<b>Application Reference Number:</b>	2025/0702
--------------------------------------	-----------

<b>Proposal Description:</b>	<i>Change of use of existing outbuilding to Hair Salon</i>
<b>Location:</b>	<i>20 Ashley Croft, Royston, Barnsley, S71 4SH</i>

| Name | Date | Scale | ASSHOWN |
|-----------------------------|---------------|----------|---------|
| Drawing No. AB/10054/004 | Revision B | | |

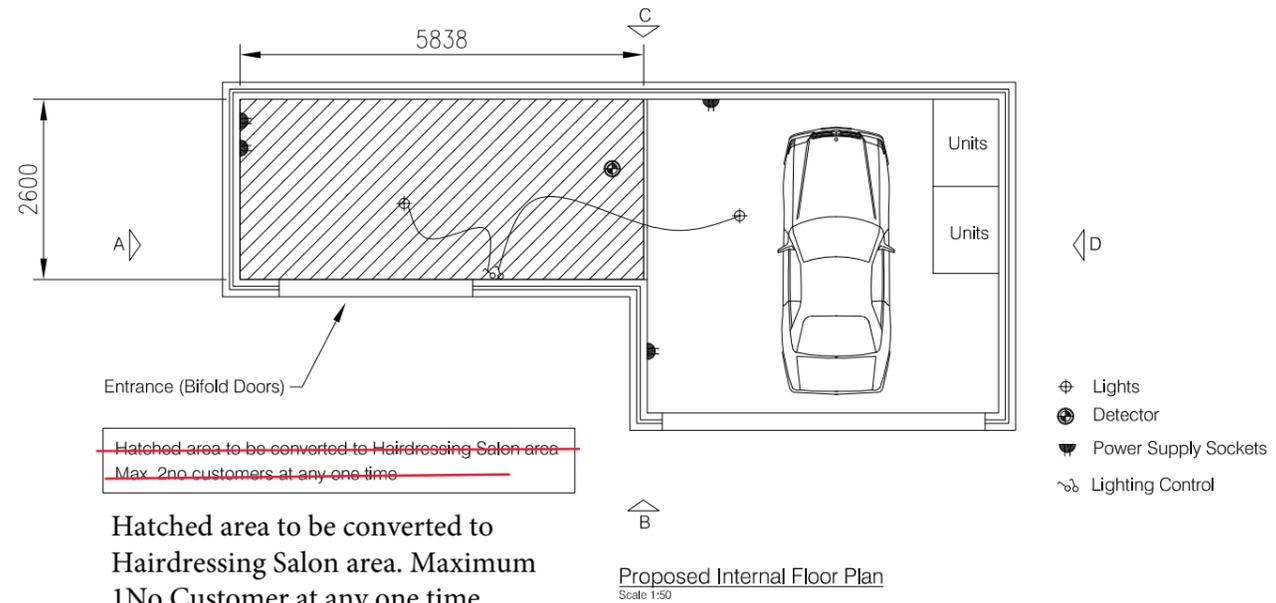
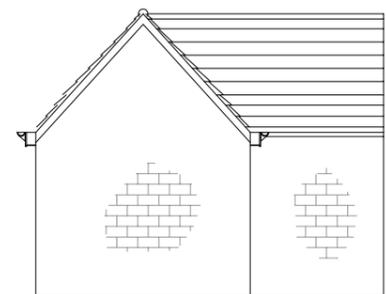
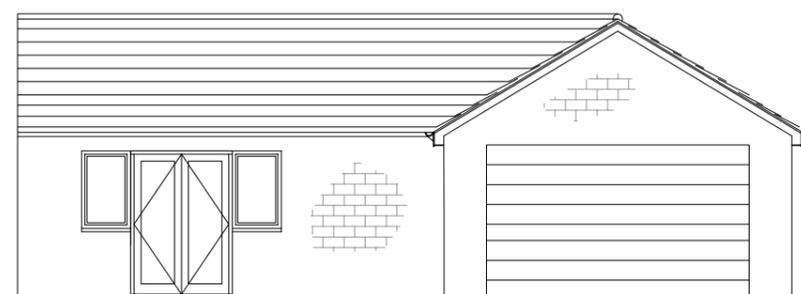
It has been necessary to make contact with the applicant to request the number of clients at the site at any one time be reduced from two to one. This was in order to prevent the use of the turning area at the end of the cul-de-sac as a result of two clients having to park in tandem of each other on the site driveway at any one time.
